## **SLAE Written Representation Submission for Deadline 11 - Comments on the Applicants Responses to SLAE written representations throughout the examination.**

## **SLAE Written Representation Submission for Deadline 11 - Comments on the Applicants Deadline 9 Response**

***TR020001-003121-8.188 Applicant's Response to Deadline 9 Submissions***

Inset 4.1 Profile of Daily Construction Traffic by Year (indicative)

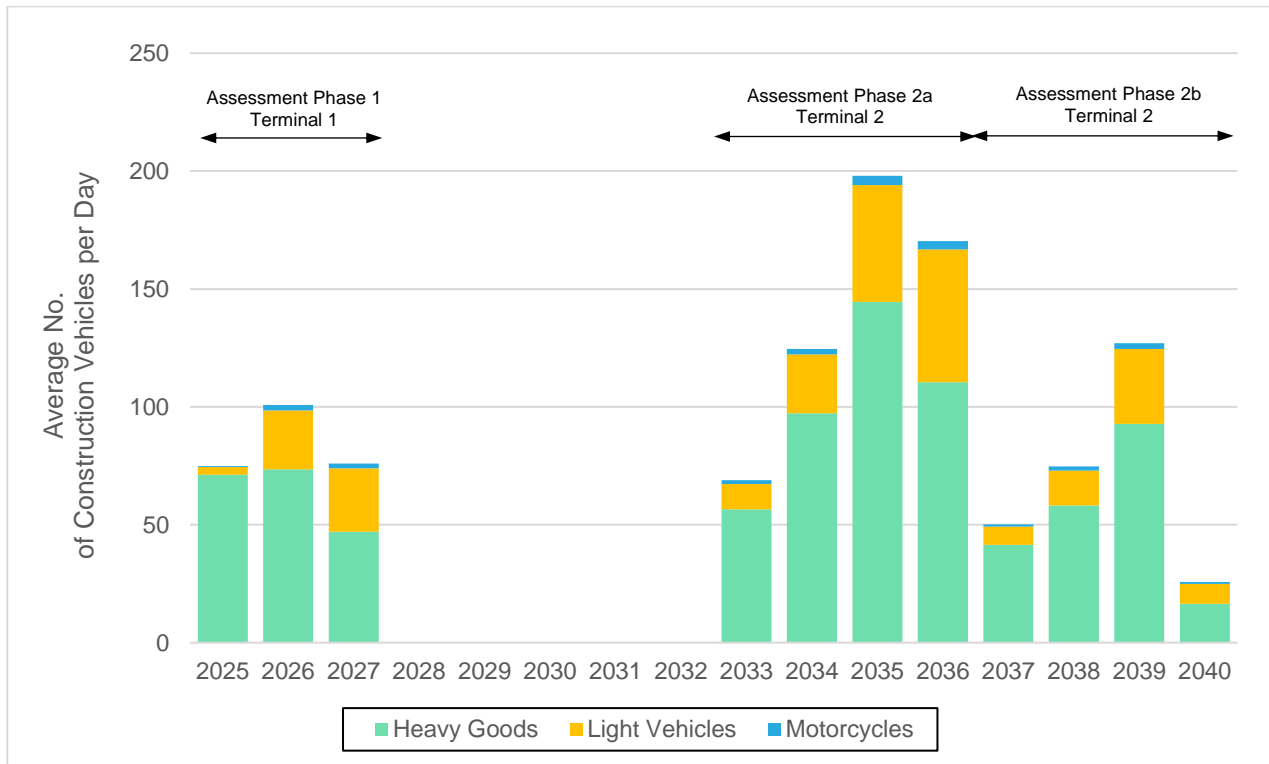
It is not easy to match the drawings in Appendix B to each Construction compound. Another example, paragraph 4.3.3a. describes Construction Compound 1, which is to be located on the Replacement Open Space Wigmore Valley Park for year 1 (drawing on page 125), but the estimated Time Operational in Table 4.1 shows 24 months, and this is not shown on the drawing on page 126. It is also not shown on the drawing in Insert 4.1 on page 21.
